**KIRKLEES METROPOLITAN COUNCIL
INVESTMENT & REGENERATION SERVICE**

DELEGATED DECISION TO DETERMINE PLANNING APPLICATIONS

Reference No: 2021/62/93912/W

Site Address: 1, Back Lane, Holmfirth, HD9 1HQ

PROPOSED ELEVATIONS

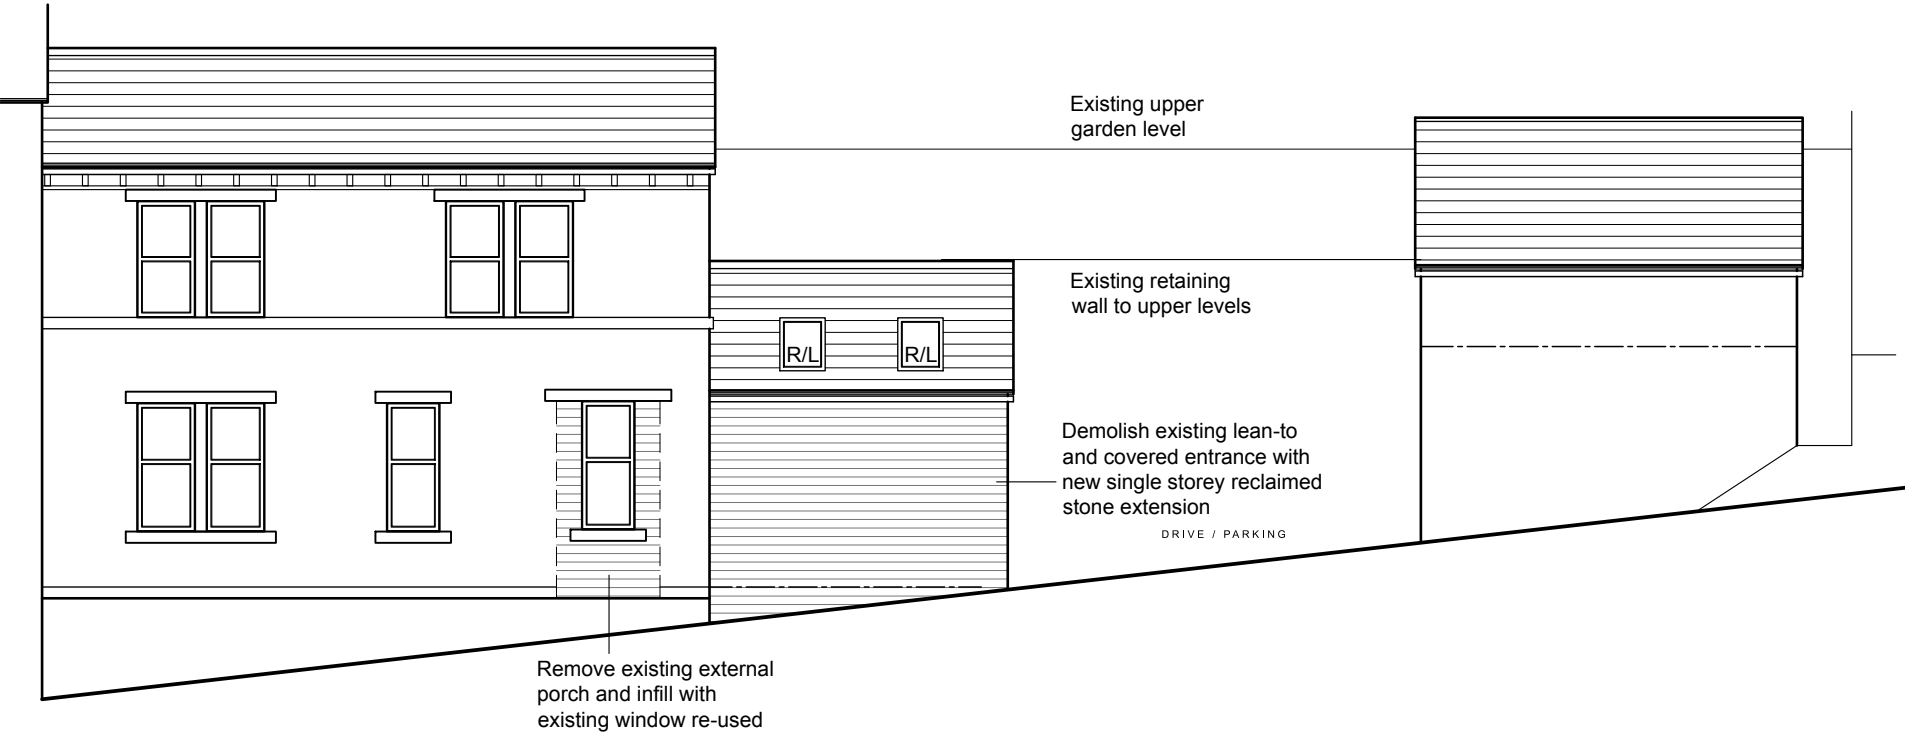
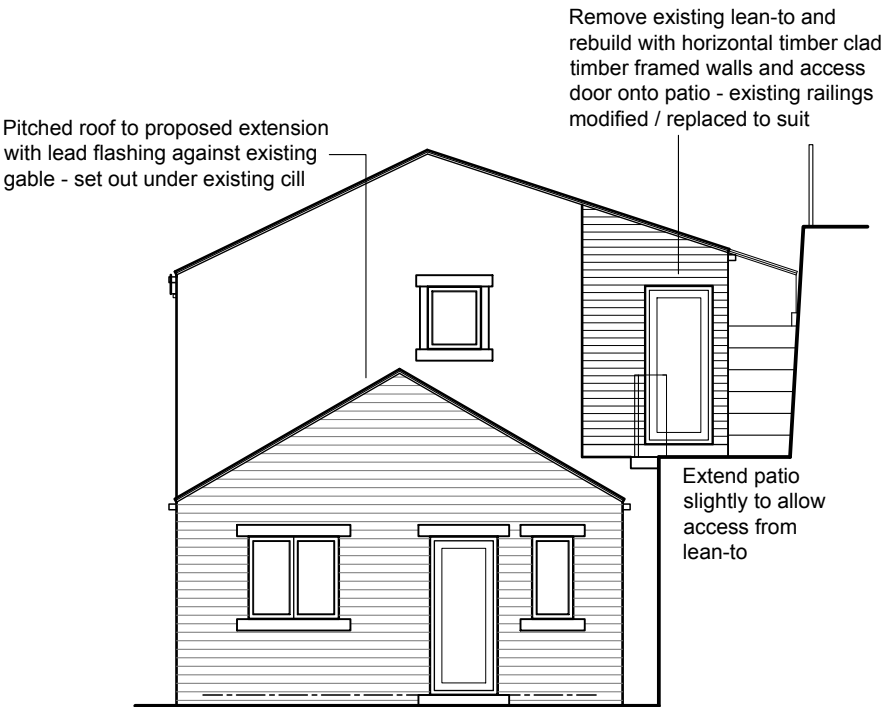
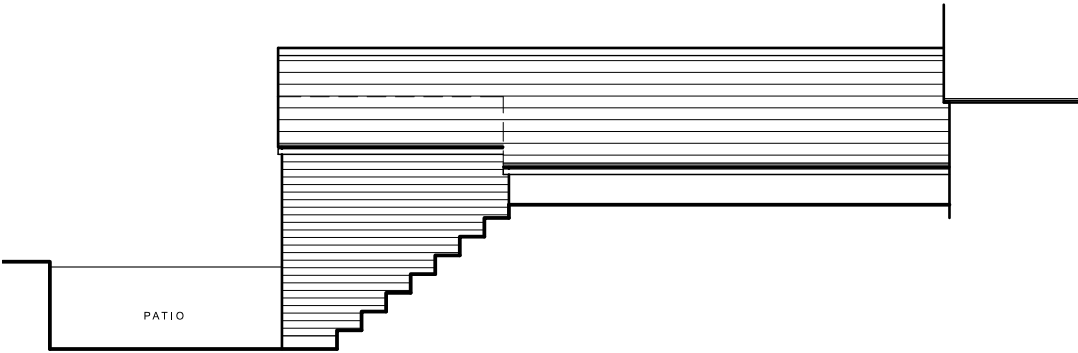
Whilst the proposed side extension would be less than two thirds of the width of the original dwelling, it would exceed a height of 4 metres (~4.3 metres measured from the highest ground level where it would be sited) and would not be flush with the front wall of the dwelling (not set back from it). Despite this, by virtue of its overall height in comparison to the existing dwelling and limited width, it is still considered that the extension would appear as a subservient addition to the existing dwelling. As a result of this, and because of the proposed use of matching materials, it is also considered that the side extension would appear as a harmonious addition to the existing dwelling. The Conservation Officer has raised no objections to this element too, subject to the use of ‘conservation’ type rooflights, which can be conditioned. Subject to conditions, it is therefore considered that the proposed side extension element would not cause detrimental harm to the visual amenities of the locality or harm to the significance of the Holmfirth Conservation Area.

Whilst visible, this proposed extension would be of limited depth and would essentially replace an existing side extension of a similar form, but would be a bit wider so that it is flush with the south side wall of the main body of the dwelling. The proposed extension would continue the roof pitch of the existing dwelling, and it is considered that its form and scale would be compatible with the existing dwelling. Whilst the use of timber cladding for the walls is not in-keeping with the materials on the existing dwelling, the extension is a small one, is only partially from Back Lane and would be replacing an existing extension which similarly does not use stone on its side elevation. Thus, the use of timber cladding on this extension is considered acceptable in this instance.

6. The rooflights on the side extension hereby approved shall be of a 'conservation' style designed to fit flush to the plane of the roof and thereafter retained as such.

NOTE: Notwithstanding the annotations within Drawings No. AL-03 Revision A and AL-04 Revision A received on the 17th December 2021, the decision does not grant planning permission for railings to the rear of the dwelling.
